Our ref: AN/2025/136678/02-L01
Your ref: H02-0511-25
Date: 10 October 2025

**Proposed development of 9 dwellings
Land off Postland Road, Crowland**

Environment Agency position

**Drainage Strategy**

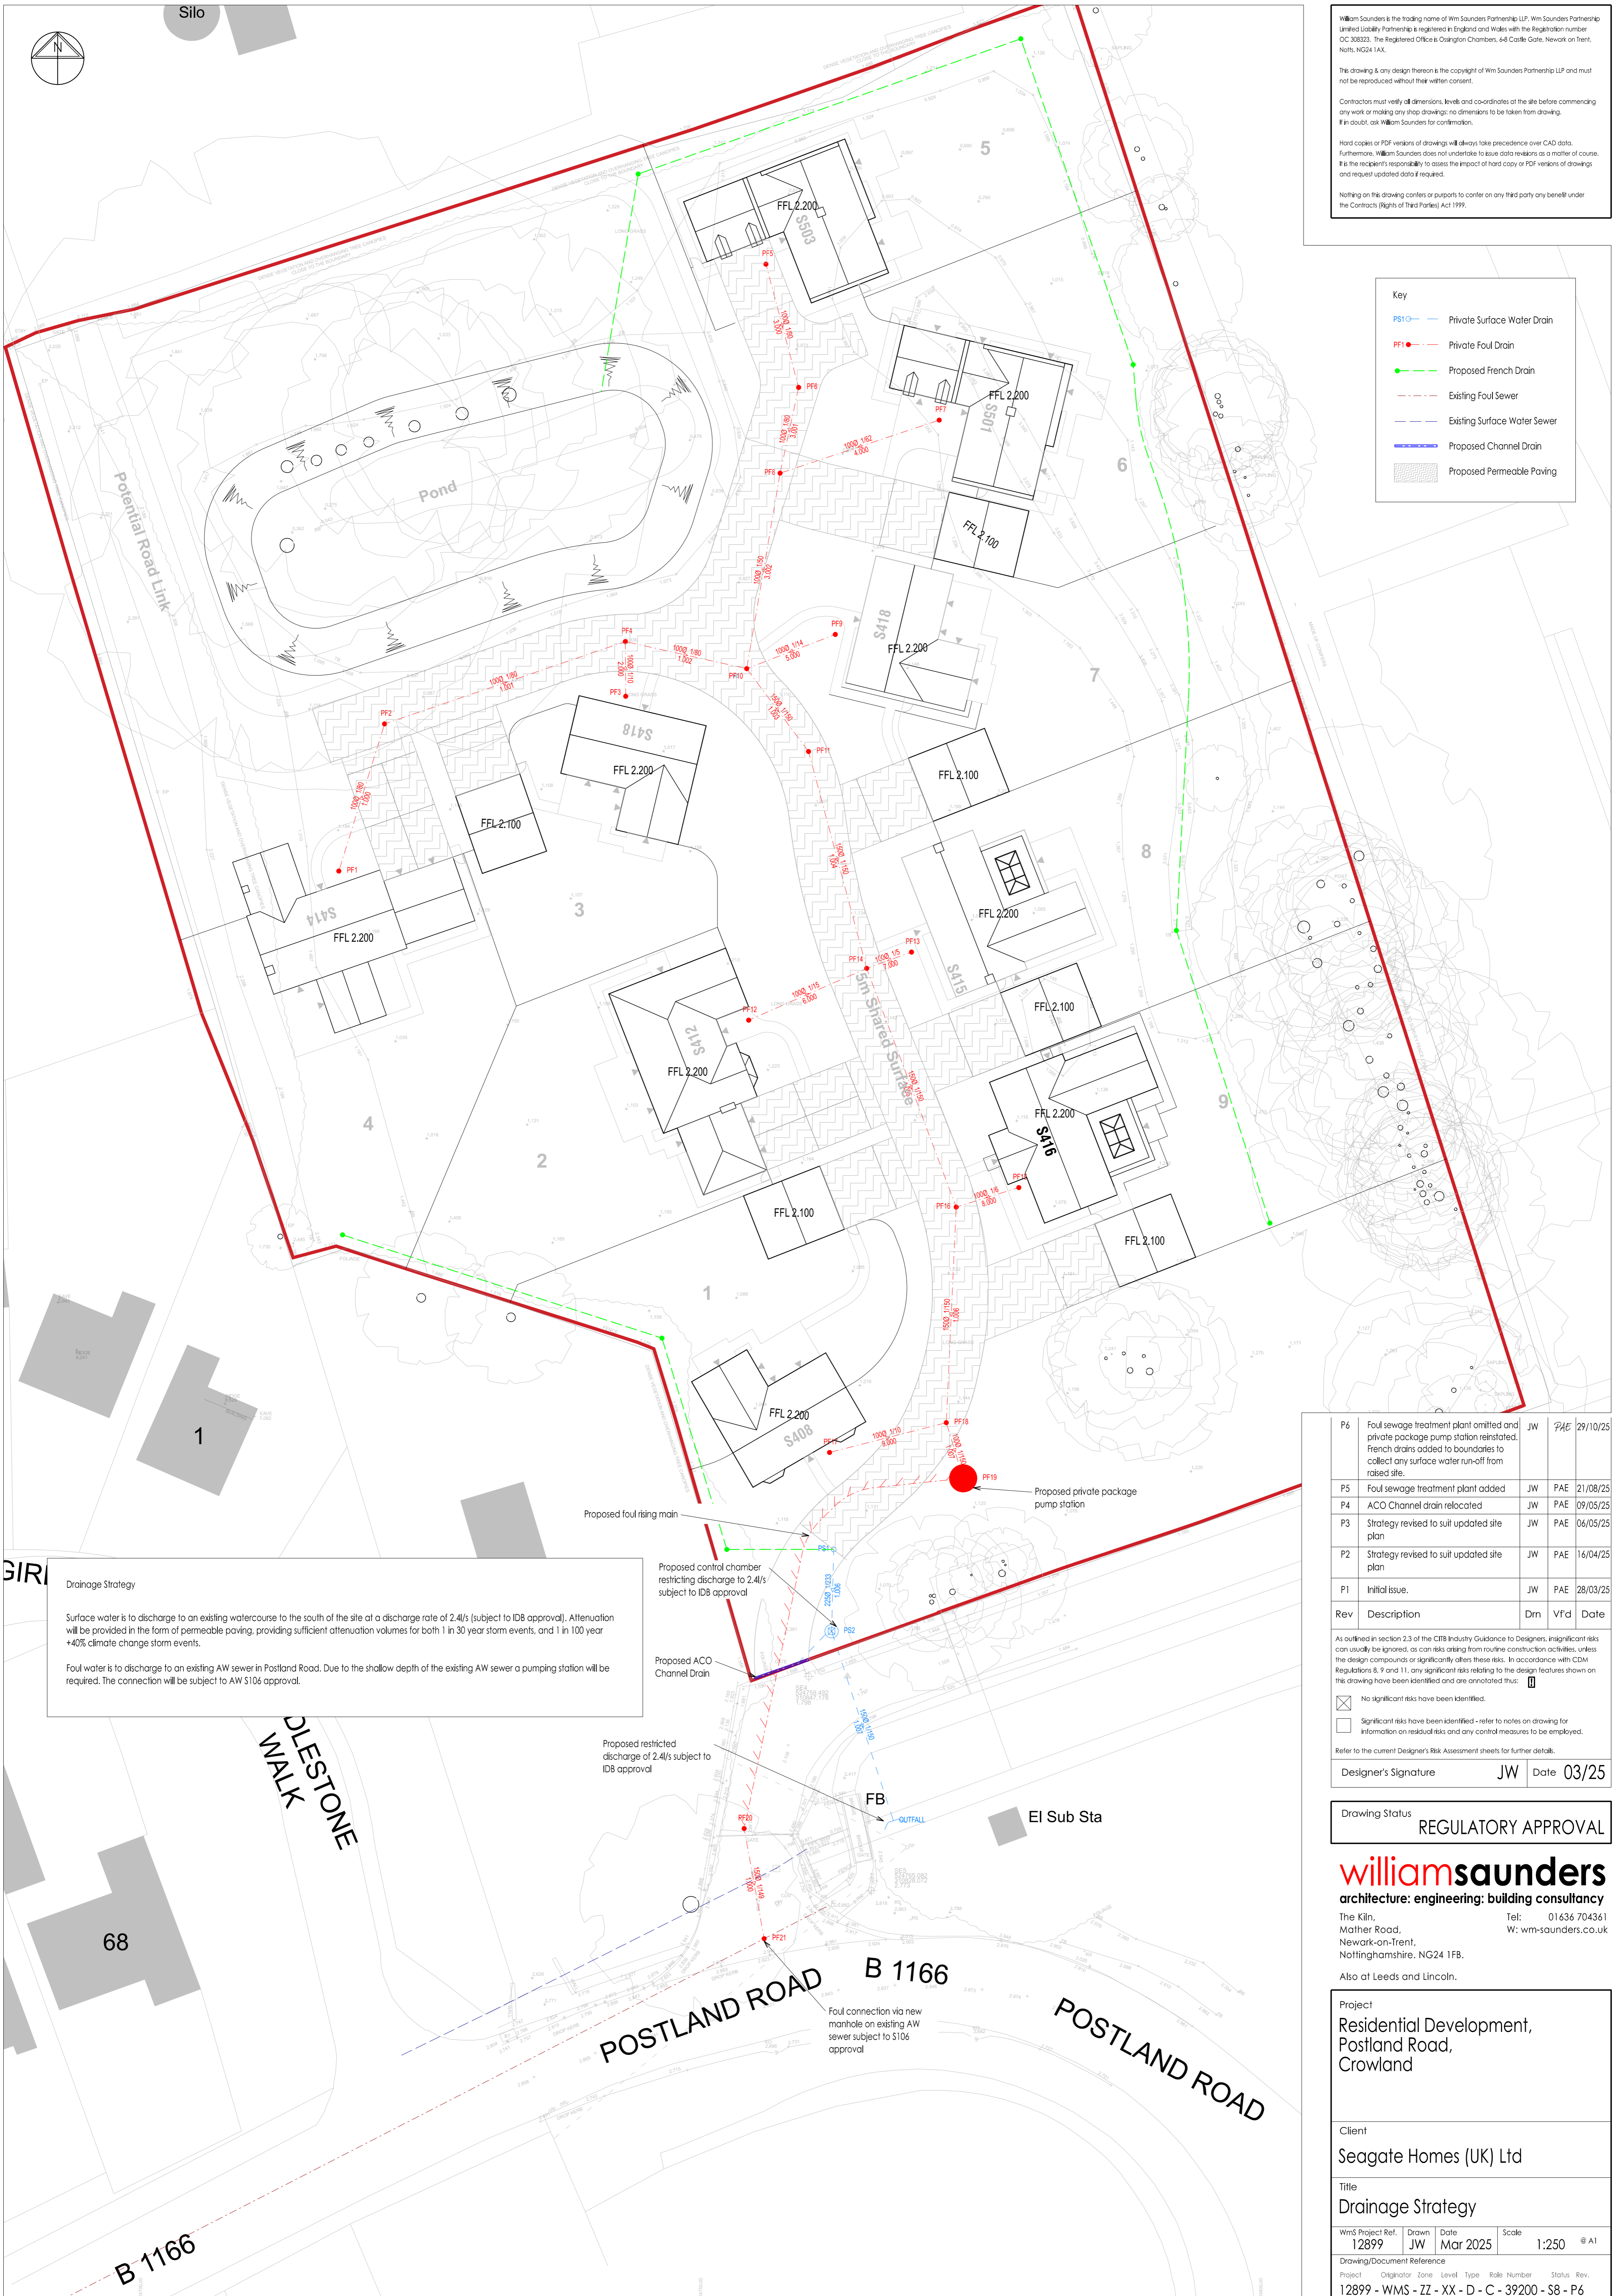
Following AWS objection to the application, an amended drainage strategy has been submitted. The submitted drainage strategy dated March 2025, ref: '12899-WMS-ZZ-XX-D-C-39200-S8-P5', prepared by William Saunders Consultancy, proposes a private sewage treatment plant for the treatment of foul water, to discharge to the watercourse to the south of the site.

Paragraph 020 of the planning practice guidance section on Water Supply, Wastewater and Water Quality (PPG) outlines that the first presumption must be to provide a system of foul drainage discharging into a mains sewer. We do not consider that a lack of capacity or lack of plans to improve capacity in the sewer are valid reasons for a development to install a private sewerage system. In such cases the developer should explore how a lack of capacity may be overcome so that their development can be connected to the mains sewer.

The AWS mains sewer runs adjacent to the site. We expect any development that is within reasonable distance to the mains sewer to connect to it, unless it can be justified on cost and/or practicality grounds otherwise.

Compliance rates for public and private sewage treatment works regulated by the Environment Agency show that private sewage treatment works do not perform as well

as public ones. Private systems are more likely to fail to comply with their environmental permit and cause pollution. Therefore, whilst we acknowledge the issues raised by AWS, we consider that overall, the use of private sewerage treatment systems is less environmentally sustainable than connection to the mains sewerage system.

Therefore, in line with Policy 4 (g) of the South East Lincolnshire Local Plan 2011-2036, **we object** to this application as we do not consider it demonstrates adequate foul water treatment and disposal.

The Environment Agency are unlikely to grant an environmental permit for a private treatment plant in this location.

We advise that consideration should be given to whether the system can be designed to overcome constraints on capacity or whether work can be undertaken off site to provide sewer capacity to accommodate the development.

We also advise that consideration should be given to whether the development can be phased to match to sewer capacity if your Local Planning Authority considers it reasonable to do so. Paragraph 020 of the PPG states: *'The timescales for works to be carried out by the sewerage company do not always fit with development needs. In such cases, local planning authorities will want to consider how new development can be phased, for example so it is not occupied until any necessary improvements to the public sewage system have been carried out.'*

We encourage engagement between your Local Planning Authority, the developer and AWS regarding solutions or aligning the development with improvements to the sewer capacity.
